KIRKLEES METROPOLITAN COUNCIL INVESTMENT & REGENERATION SERVICE

DELEGATED DECISION TO DETERMINE APPLICATIONS FOR CONSENT, AGREEMENT OR APPROVAL REQUIRED BY CONDITION

Reference No:	2026/44/90441/W
Site Address:	Huddersfield Bus Station, Upperhead Row, Huddersfield, HD1 2JN
Description:	Discharge of details reserved by conditions 11 (bins), 15 (BEMP), 22 (Phase II Intrusive Site Investigation Report) on previous permission 2025/91604 for variation condition 2 (plans) on previous permission 2024/92302 for refurbishment comprising (phase 1): facade improvements including Henry Street entrance; replacement shop fronts; alterations to external bus apron; extension and alterations to existing barrier within the bus alighting lane adjacent to Henry Street; (phase 2): new entrance canopy; public realm improvements; cycle hub; facade improvements including replacement shop fronts
Recommending Officer:	Liz Chippendale

DECISION – Discharge of Condition – Split Decision

E2 Bin Store South Elevation  
Scale: 1 : 100

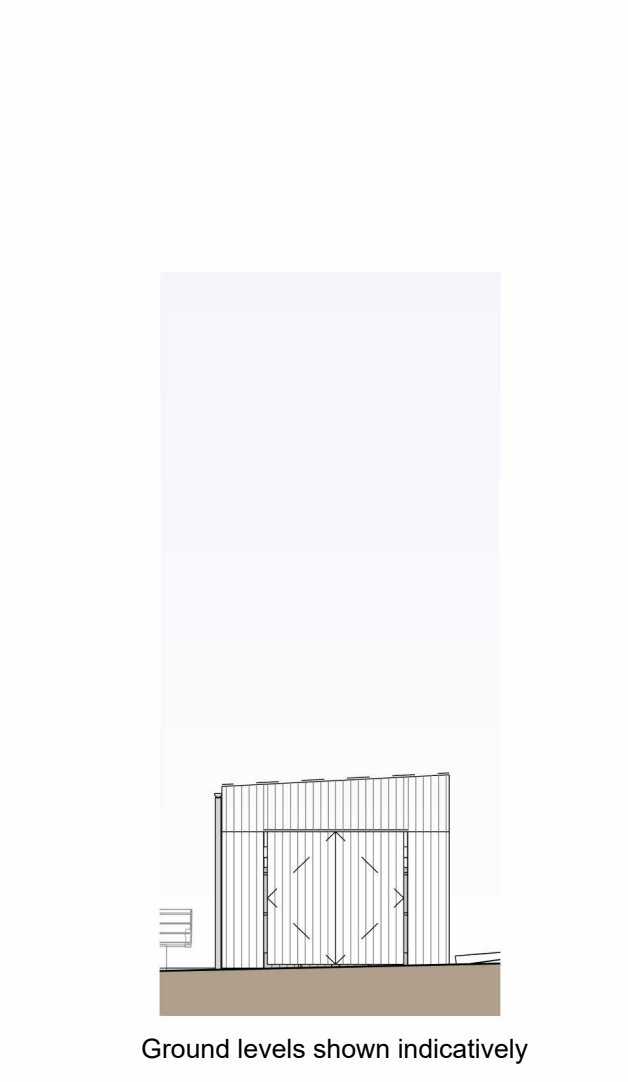
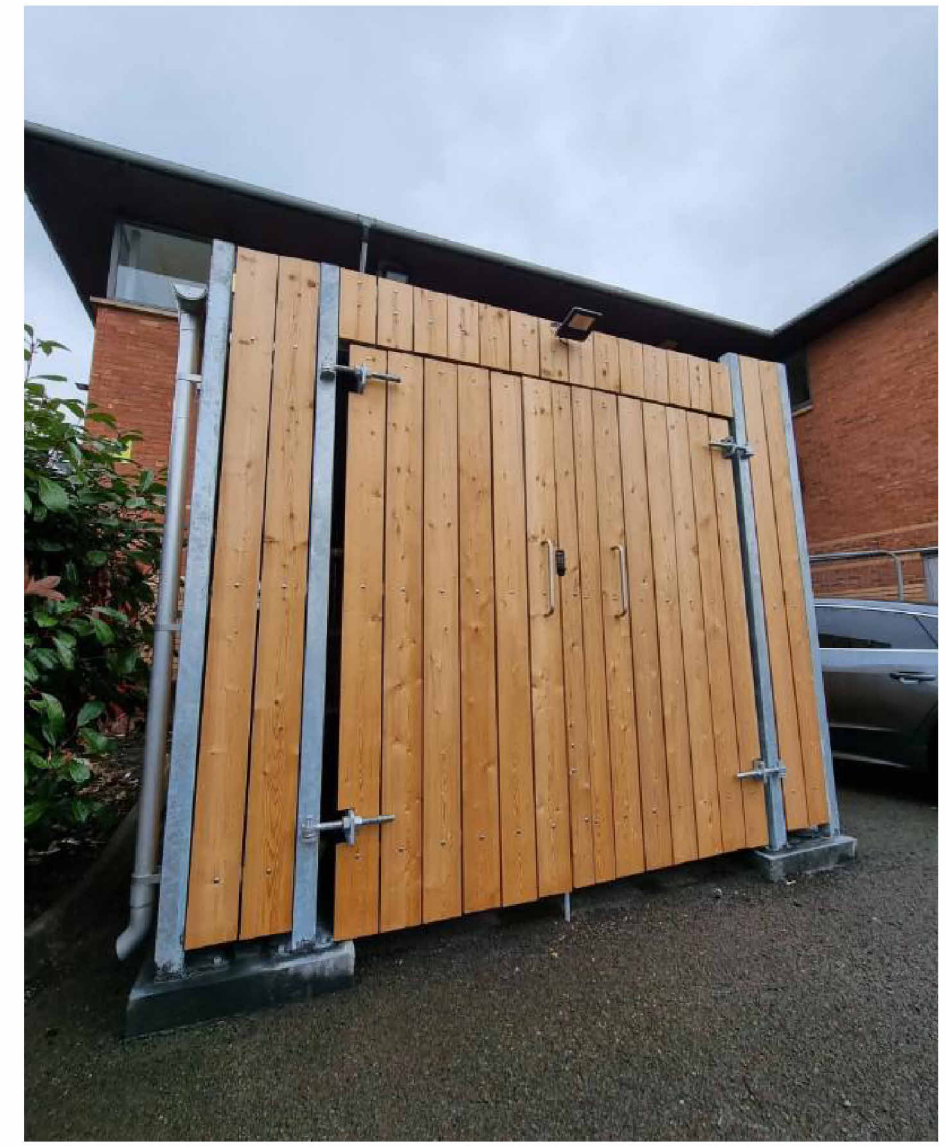
Part of the proposals are to formalise the existing bin storage located on the bus station forecourt on Upperhead Row with a wooden bin store that would remove the bins from open display in a prominent position on the pedestrianised area outside the bus station to enhance the street scene and bus station refurbishment.

It is noted that the location of the proposed bin store is within the adopted highway and is not included within the proposed stopping up zone underneath the new canopy. It is the Local Highway Authority's policy that formal bin storage should not take place within the adopted highway and because of this we would have submitted an objection to the proposals and requested that the condition should not be discharged.

The bin store only shows room for 4 bins, this is too small and needs to be larger to be able to accommodate 8 bins that are currently on the site. Given the information provided by the developer the WCA cannot agree to the Discharge of Condition 11 for the site until the bin store is made larger.

We would not wish to see a precedent set that will allow other developments within town centre locations to propose waste stores on the adopted highway in contravention to existing LHA policy. However, given the information presented above, for this specific instance only, we would, on balance, not wish to object to the discharge of condition 11 of 25/91604.

I understand now where the 4 containers figure came from and that the other waste containers are to be dealt with by the Bus Station. Therefore, I am happy with the bin store holding the 4 containers as detailed in the latest plan.

Site Plan

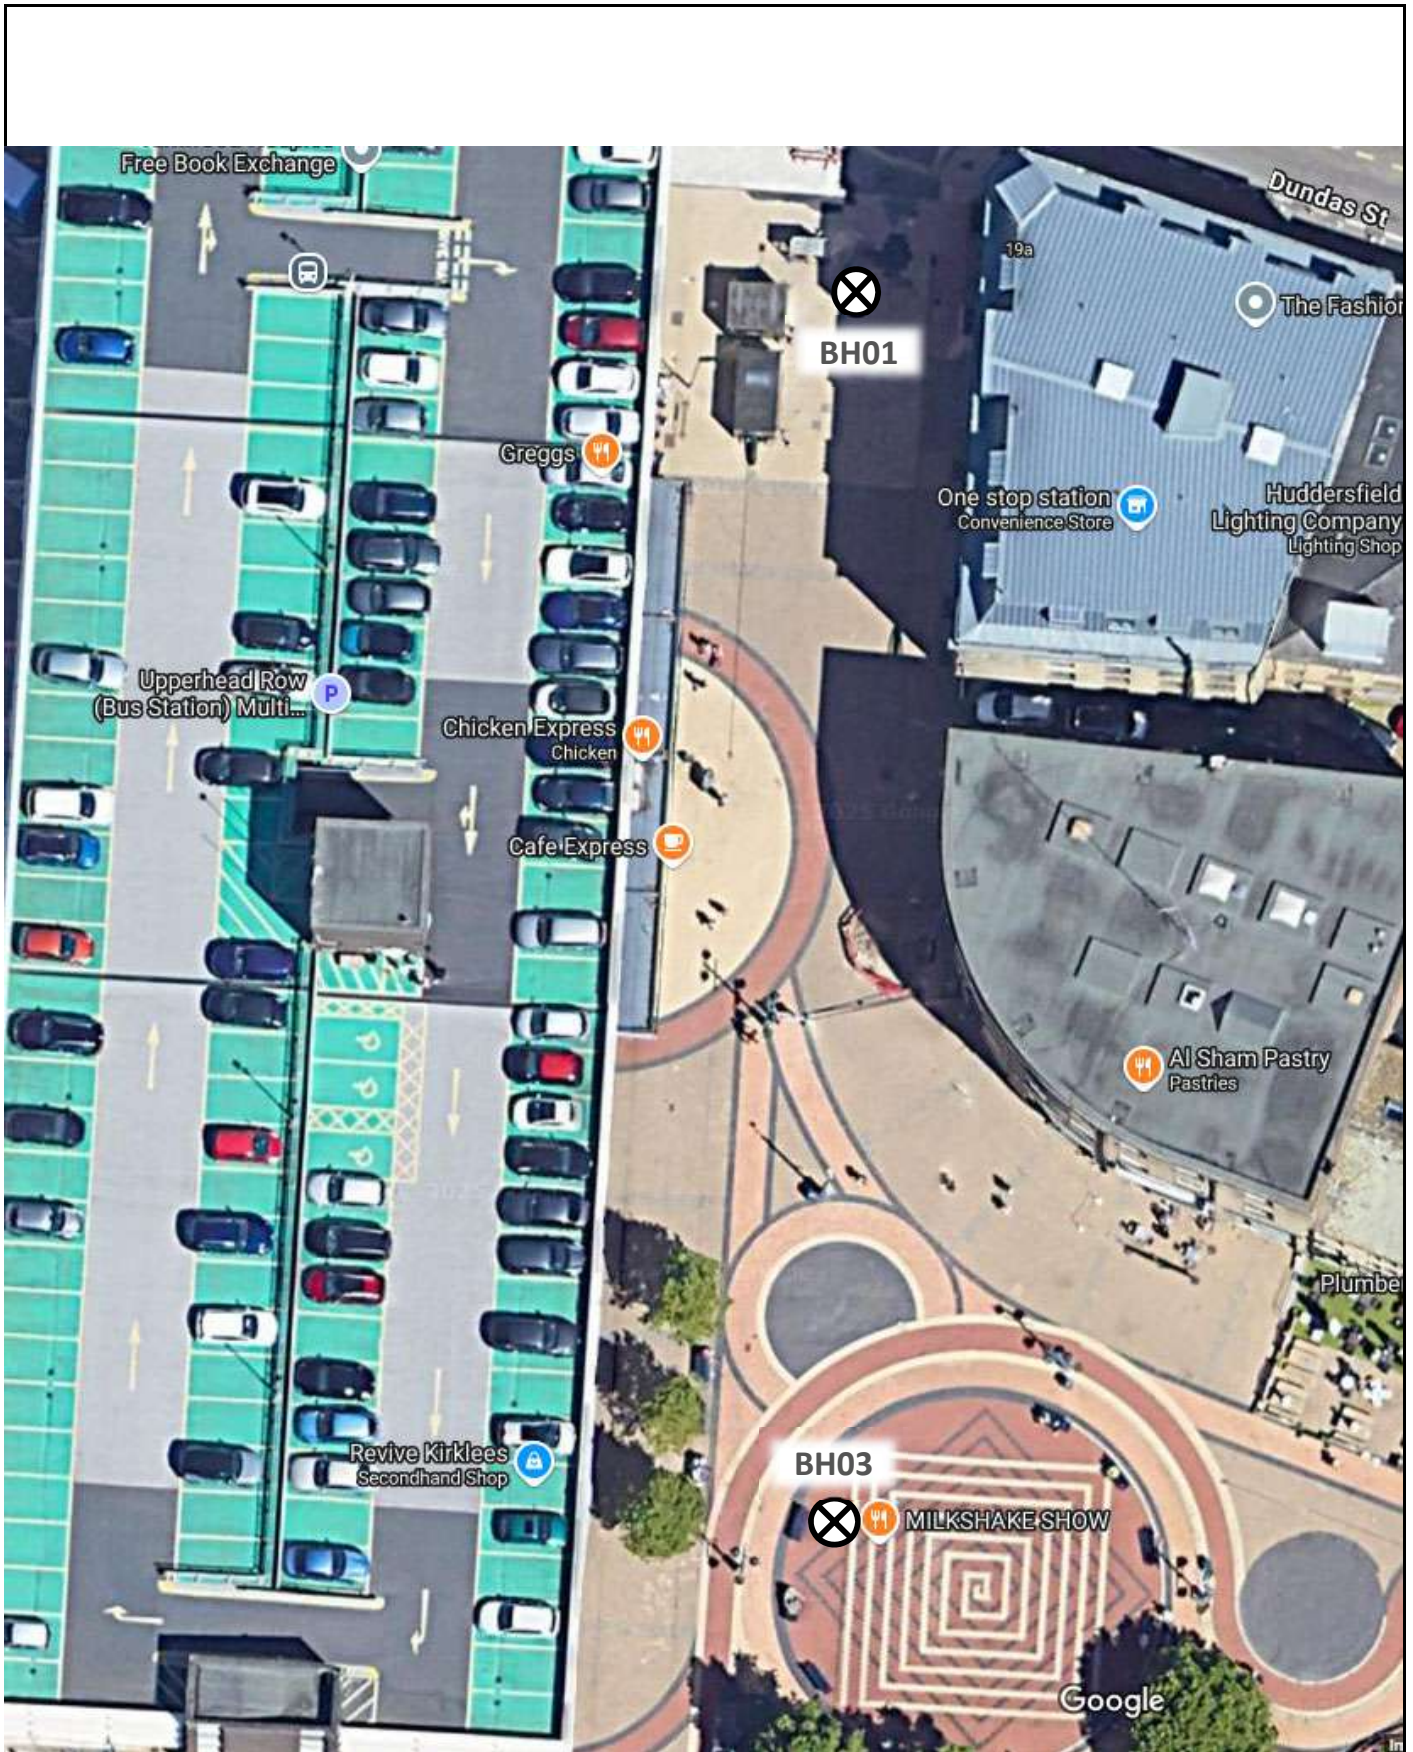
We are informed fieldworks were undertaken between the 12th & 14th, and 17th & 18th June 2025. They included two windowless sample boreholes with rotary core and rotary open-hole follow-on, with, Installation of two monitoring standpipes. The report explains, a third borehole was not undertaken due to time constraints. Good practice guidance advises a minimum of 3 investigation points and 3 monitoring locations where a gas risk has been identified.

Officers concur with the expert advice provided by KC Environmental Health that further details are required. Officers advise that a minimum of 3 investigation points and 3 monitoring locations where a gas risk has been identified should be submitted. At this stage only 2 investigation points are detailed.
